February 24, 1998

RE: DRAINAGE PLAN FOR WALGREENS @ LAS MARCADAS (C12-D002C1)
ENGINEER'S STAMP DATED 1/30/98

**WALGREENS - LAS MARCADAS
 GRADING AND DRAINAGE PLAN**

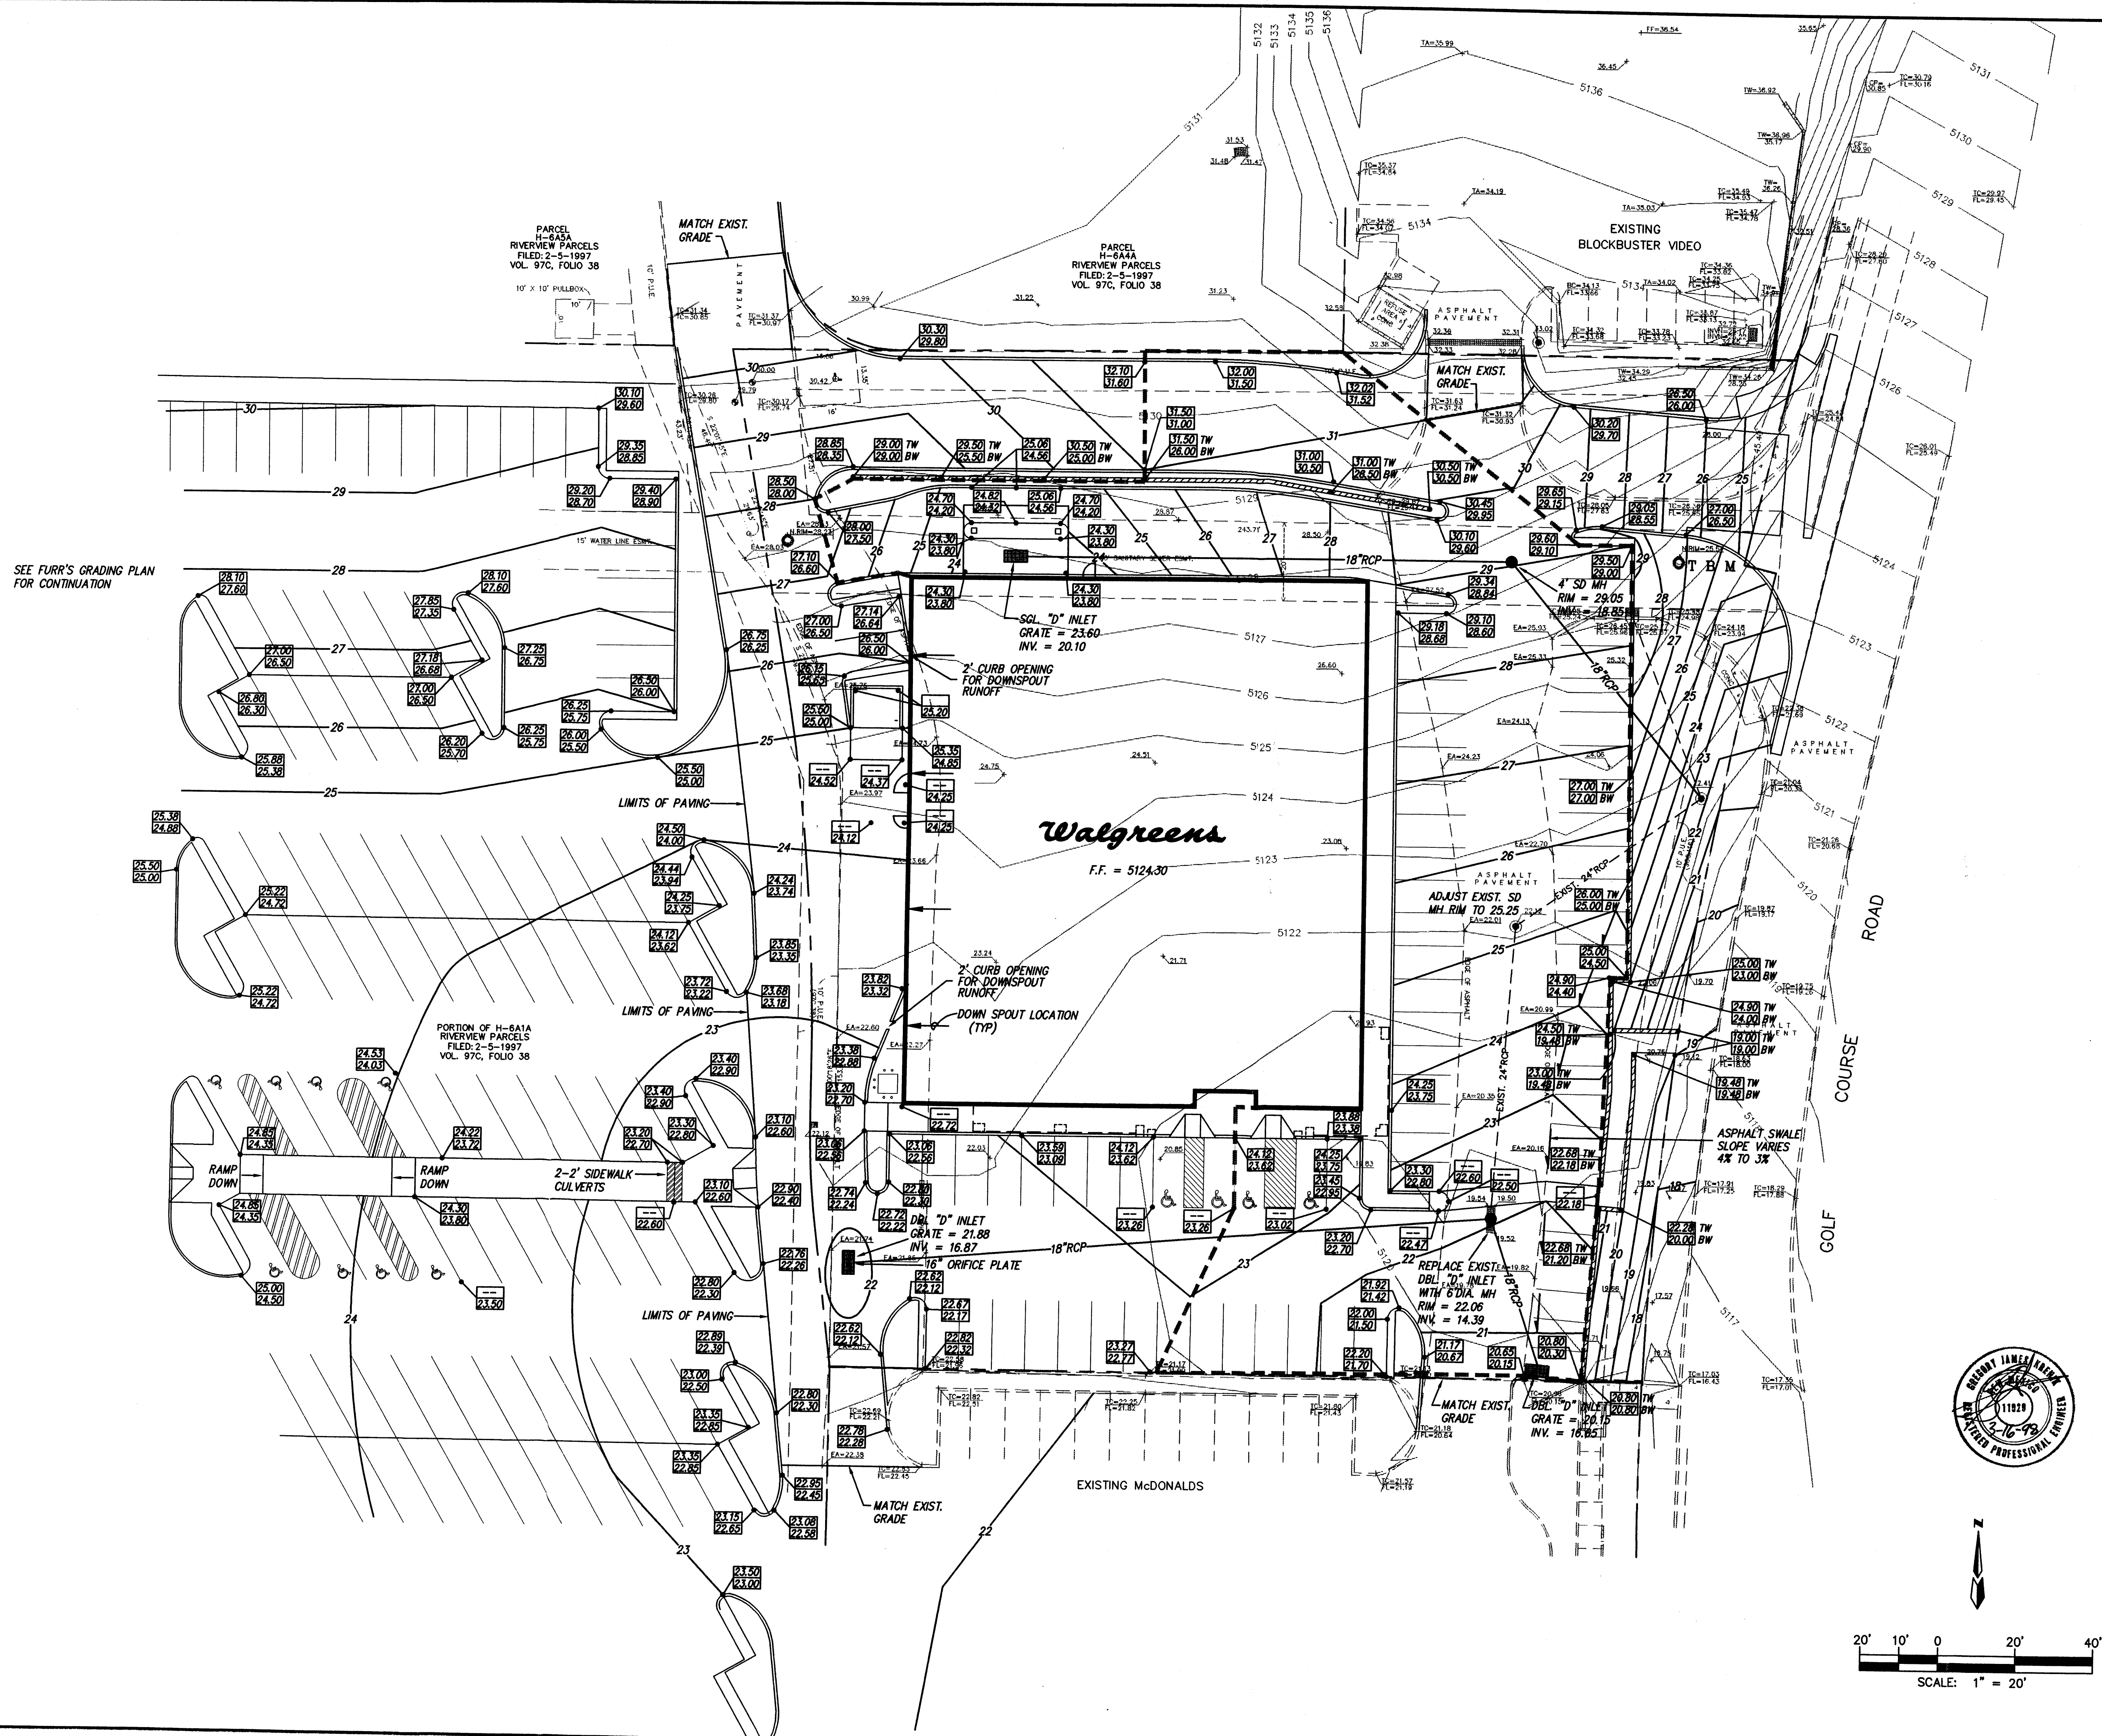
1. Provide curb cuts on areas where the down spouts will dump into areas bound by curbs.
2. Include slopes on the plan drawing for all swales within the paved areas.
